**KIRKLEES METROPOLITAN COUNCIL
INVESTMENT & REGENERATION SERVICE**

Reference No:	2023/62/93742/W
Site Address:	land adj The White House development, Chain Road, Slaithwaite, Huddersfield, HD7 5TY
Description:	Erection of 2 detached dwellings
Recommending Officer:	Lucy Taylor

DECISION - REFUSED

Officer Report.

Block Plan showing proposed levels
1 : 500

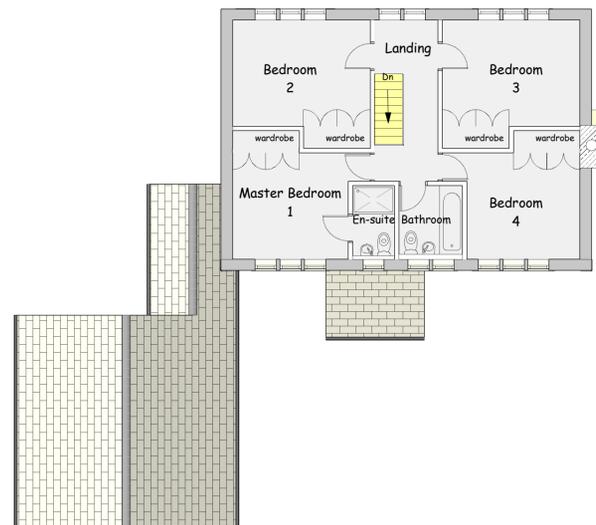
It should also be noted that the indicative plan suggests a large expanse of hardstanding to the front elevation of the proposed dwellings. This is considered to be contrary to Principle 5 of the Housebuilders Design Guide SPD, which sets out that careful consideration should be given to accommodating car parking, to ensure that it is not visually dominant.

No details of the sight lines from the proposed new access onto Chain Road are provided. The speed limit along Chain Road is 60mph. HDM would recommend that speed surveys are undertaken, and the applicants are asked to demonstrate that their proposed sight lines are satisfactory for the 85-percentile speed of vehicles along this section of Chain Road.

No details of bin collection points are provided. Bin collection points should be provided to both dwellings to enable bins to be presented on collection day without either obstructing the highway or proposed driveway.

First Floor Plan
1 : 100

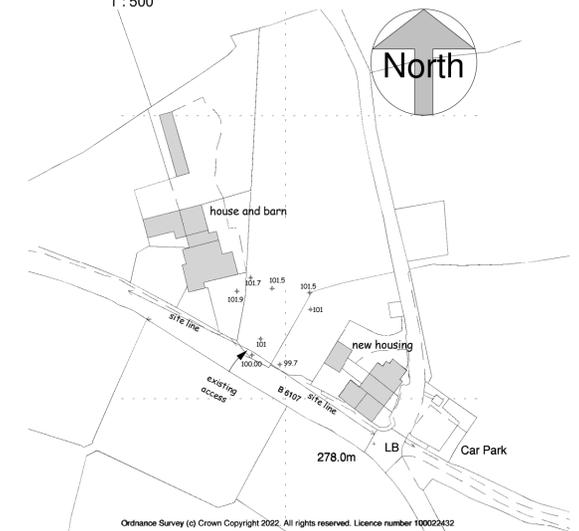
In this instance, the nearest residential property to the application site is Slate Pitts to the west. This neighbouring property benefits from large areas of glazing within the side elevation of their flat roof extension, which is adjacent to the proposed new dwelling, No.1. The closest side elevation to the new built form (the rear elevation of the double garage at No.1) would be separated from this glazed side elevation by approximately 3.5 metres. All other proposed built form would be separated from this side elevation of Slate Pitts by approximately 8 metres or further. The only window proposed in the side elevation, to face towards Slate Pitts would serve a utility. Given the close proximity of this window in relation to this neighbouring property, if

planning permission were to be granted, a condition would be imposed to ensure that this window be obscurely glazed. With the inclusion of this aforementioned condition, given the layout of the proposed dwellings and the separation distances present, it is not considered that the development would result in significant impacts of undue overbearing, overshadowing or overlooking with regards to the neighbouring property of Slate Pitts.
